DEVELOPMENT REVIEW COORDINATOR
POST APPROVAL PROJECT CHECKLIST

Project Name: Mixed Use Development - Veroneau

Project Name: **Mixed Use Development at 321 Commercial Street (corner Maple Street)**
Project ID: 2012-615 CBL: 40-E-3
Address: 321 Commercial Street
Applicant: J B Brown & Sons
Planner: Jean Fraser

CONSTRUCTION MANAGEMENT  
 AND TRAFFIC CONTROL PLAN

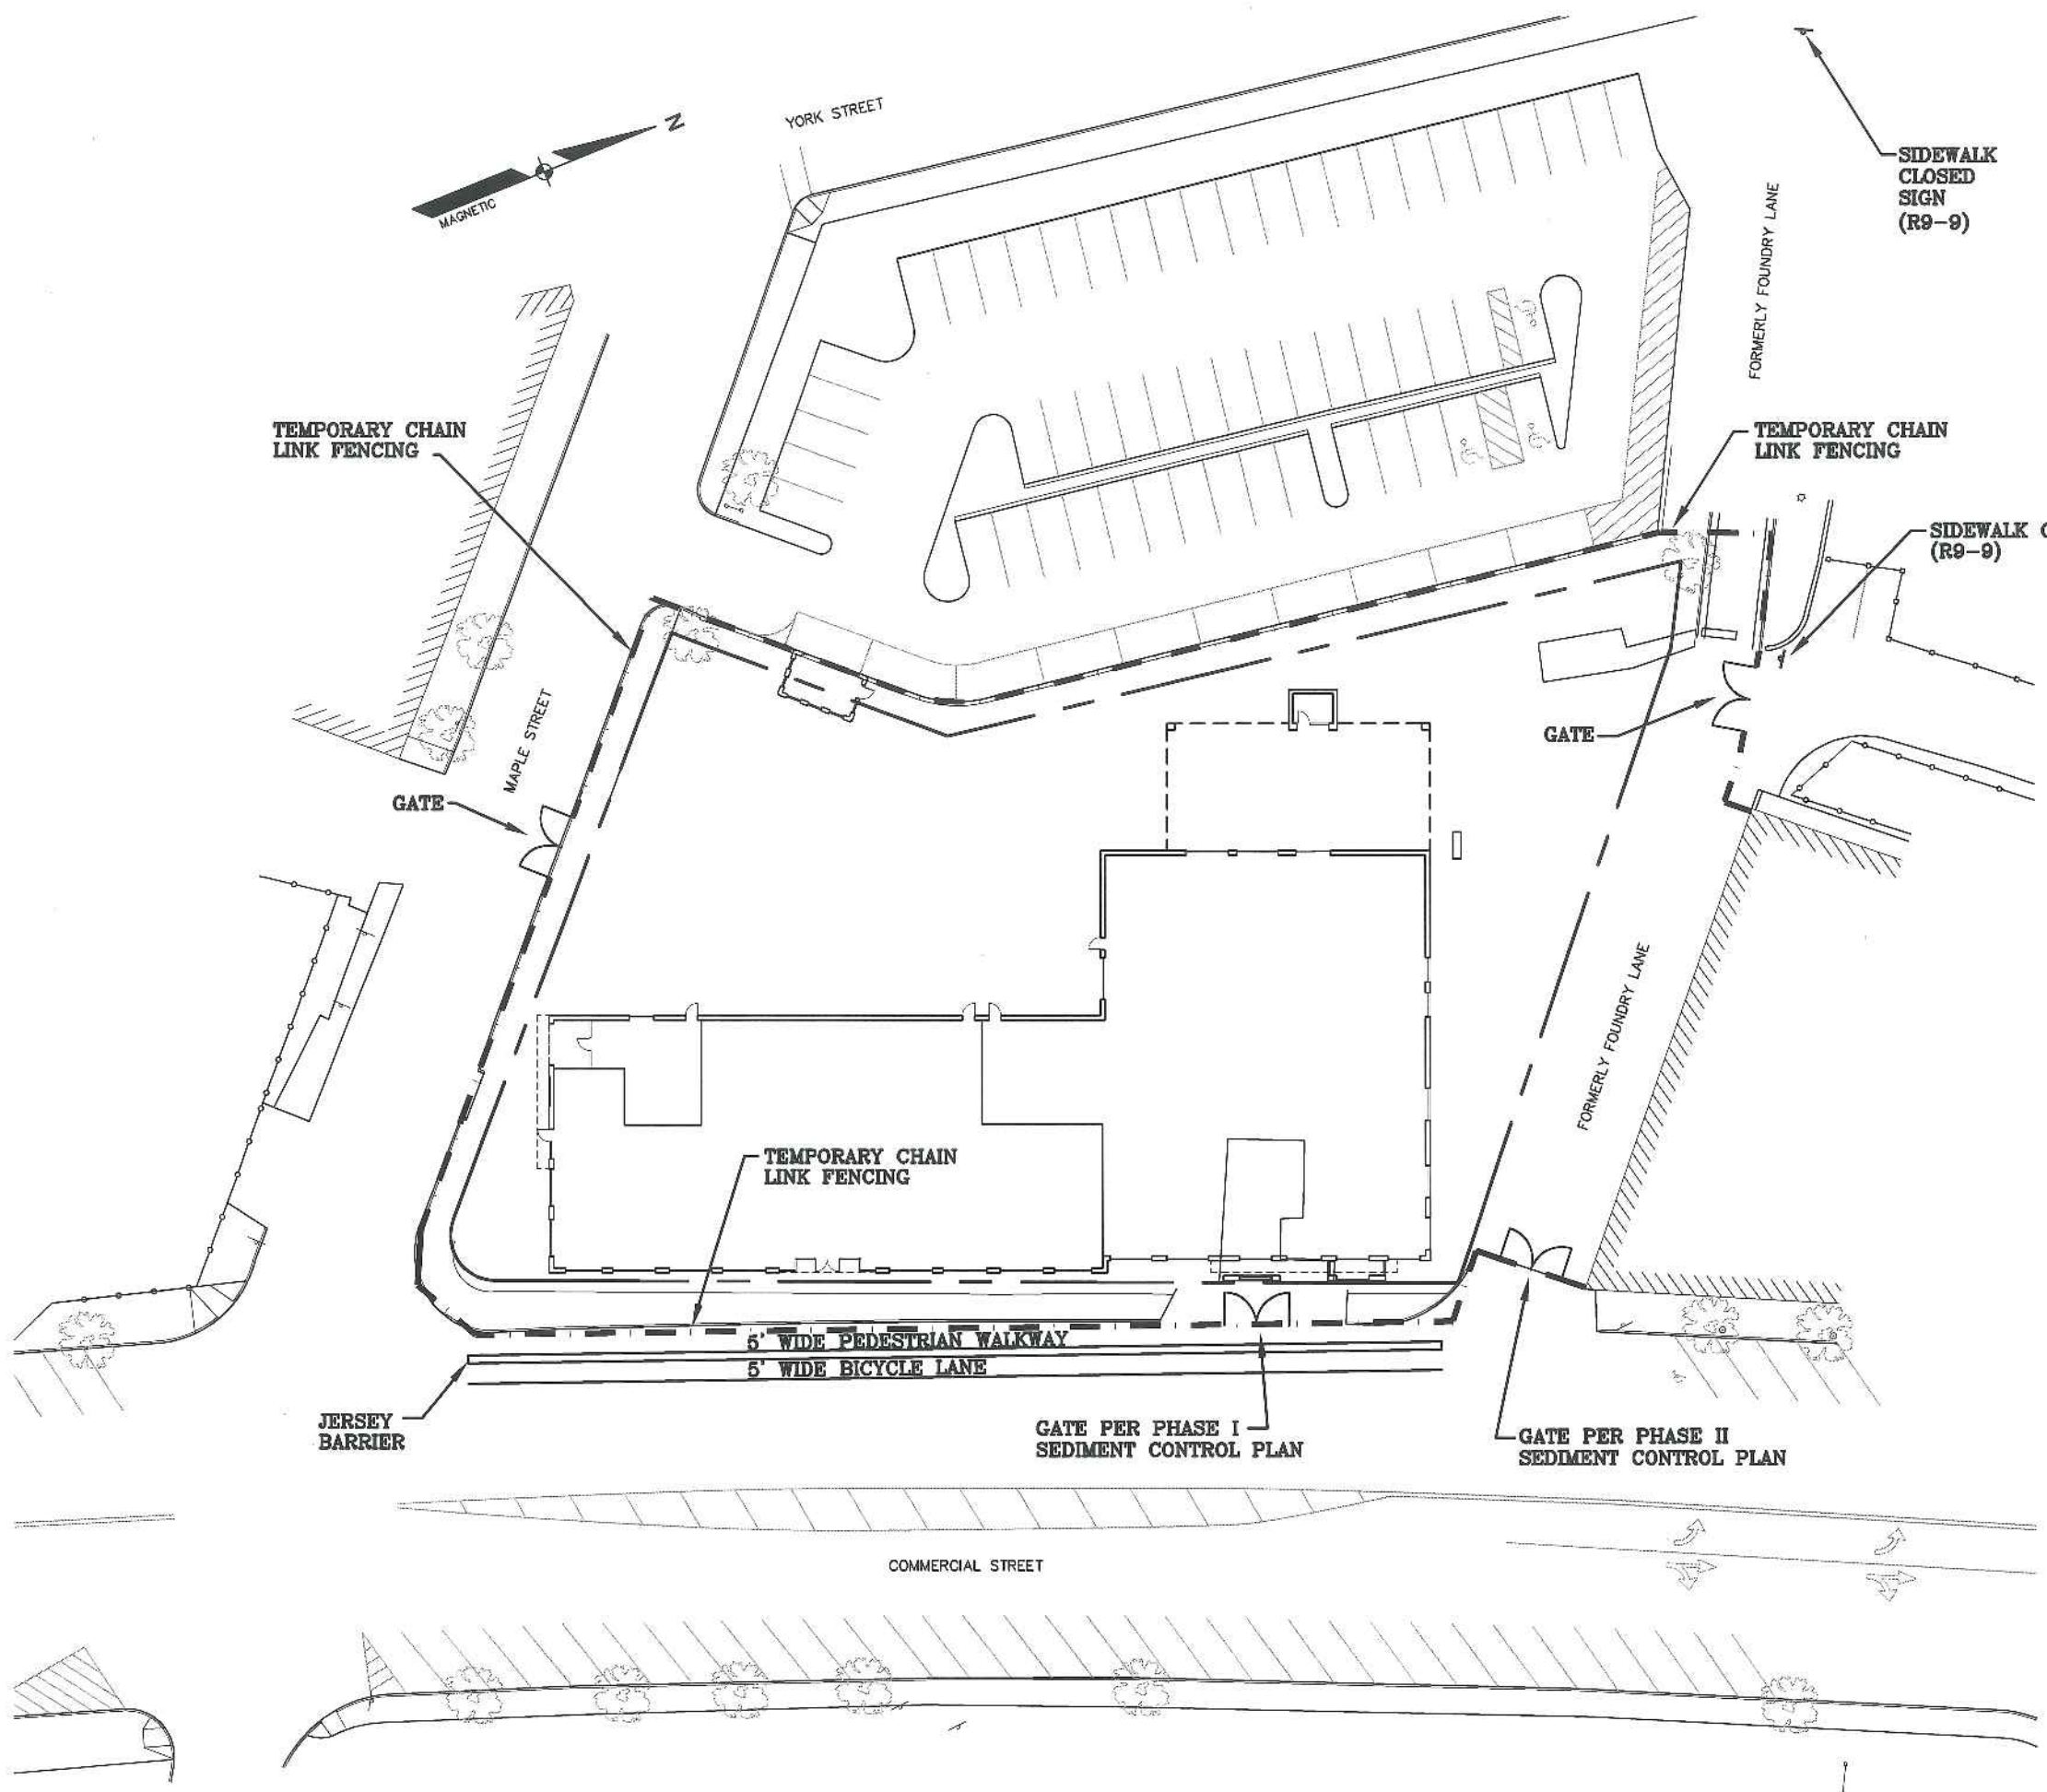
6. That the applicant shall submit, for review and approval by the Planning Authority and the Department of Public Services, a revised Construction Management Plan that addresses the comments of Tom Errico, Traffic Engineering Reviewer, dated 1.16. 2012 prior to the start of construction; and

Status: The applicant shall submit a detailed construction management plan for review and approval prior to construction. I would note that the sidewalk detour on Maple Street includes a section where a sidewalk is not provided and thus changes may be required. I would also note that with the closure of Foundry Lane, traffic will be diverted to Center Street (behind the Baxter Building). This diversion may require changes to existing circulation restrictions. Lastly, construction vehicle access needs to be reviewed particularly in light of the proposed Charter School which is expected to be open later this summer.

DATE: 10-22-12  
 SCALE: 1"=20'  
 DRAWN BY: BJS  
**C04**  
 SHEET: 4 OF 14

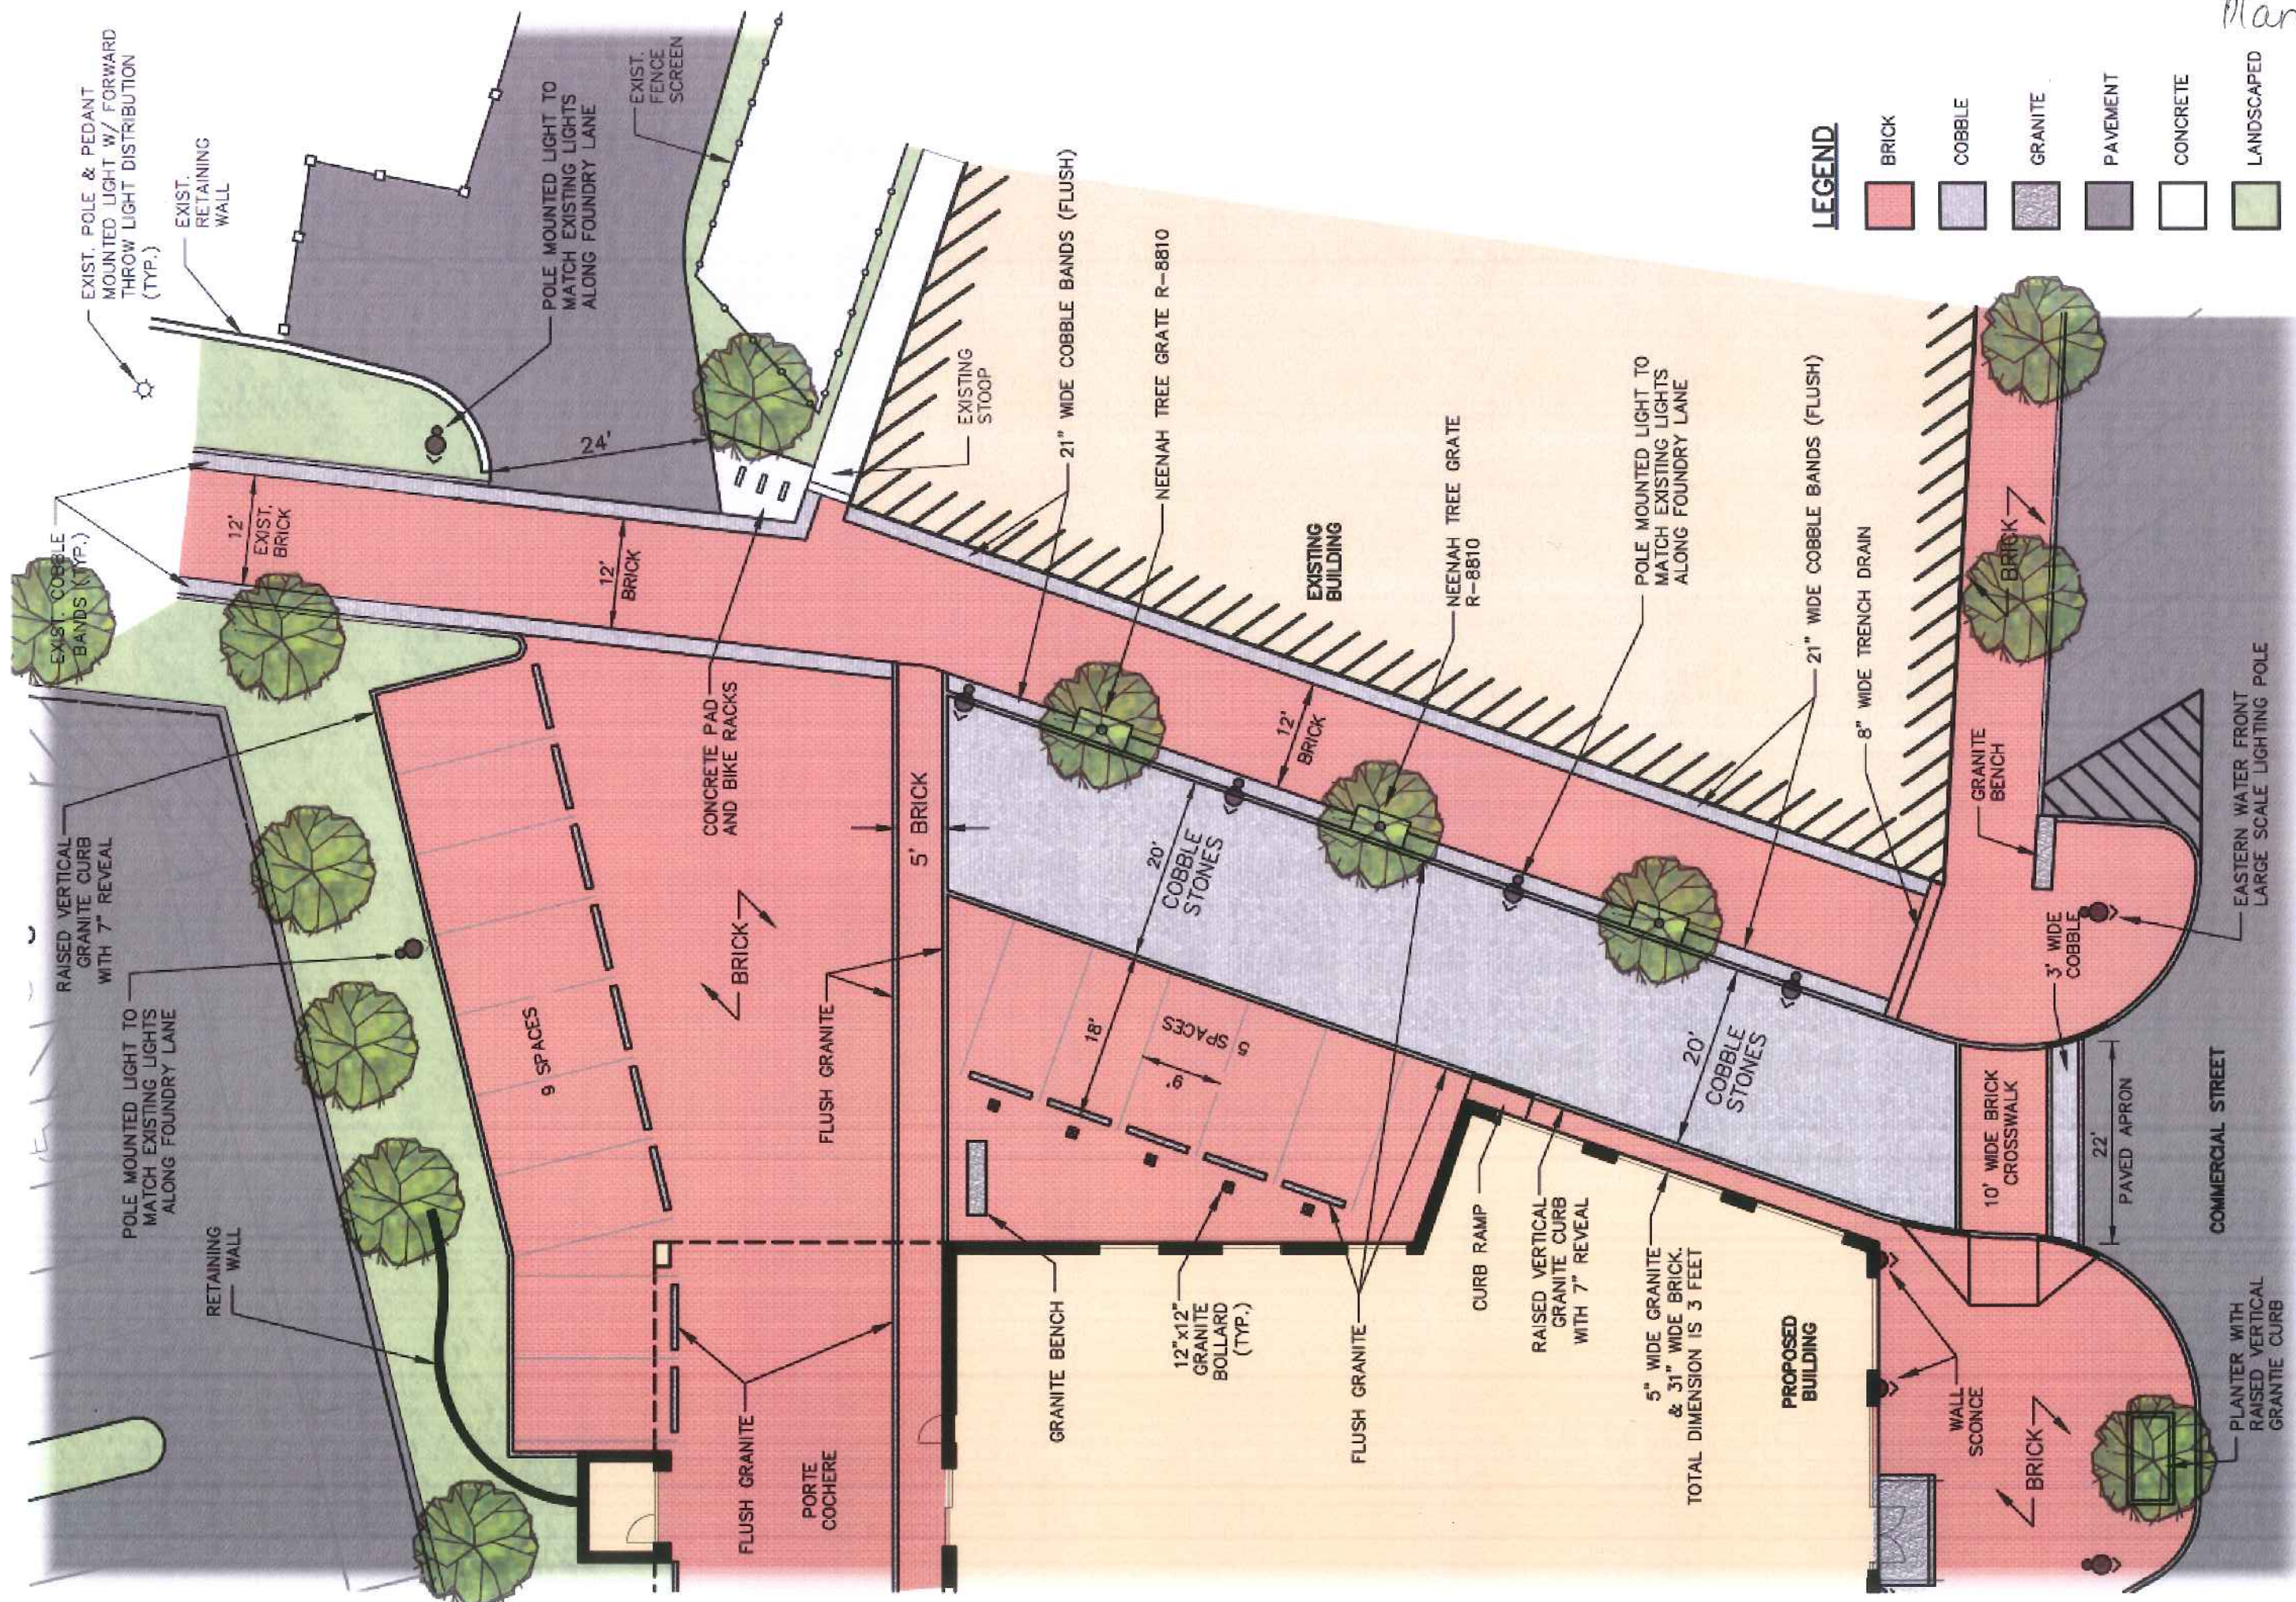
The Planning Board waives Technical Standard, Section 1.20.1, to allow a reduction in the required sight distance to the centerline of the crosswalk on the east side of Commercial Street, subject to the removal of an additional parking space nearest to the crosswalk, as based on Plan CO4 Rev 1.15.2013.
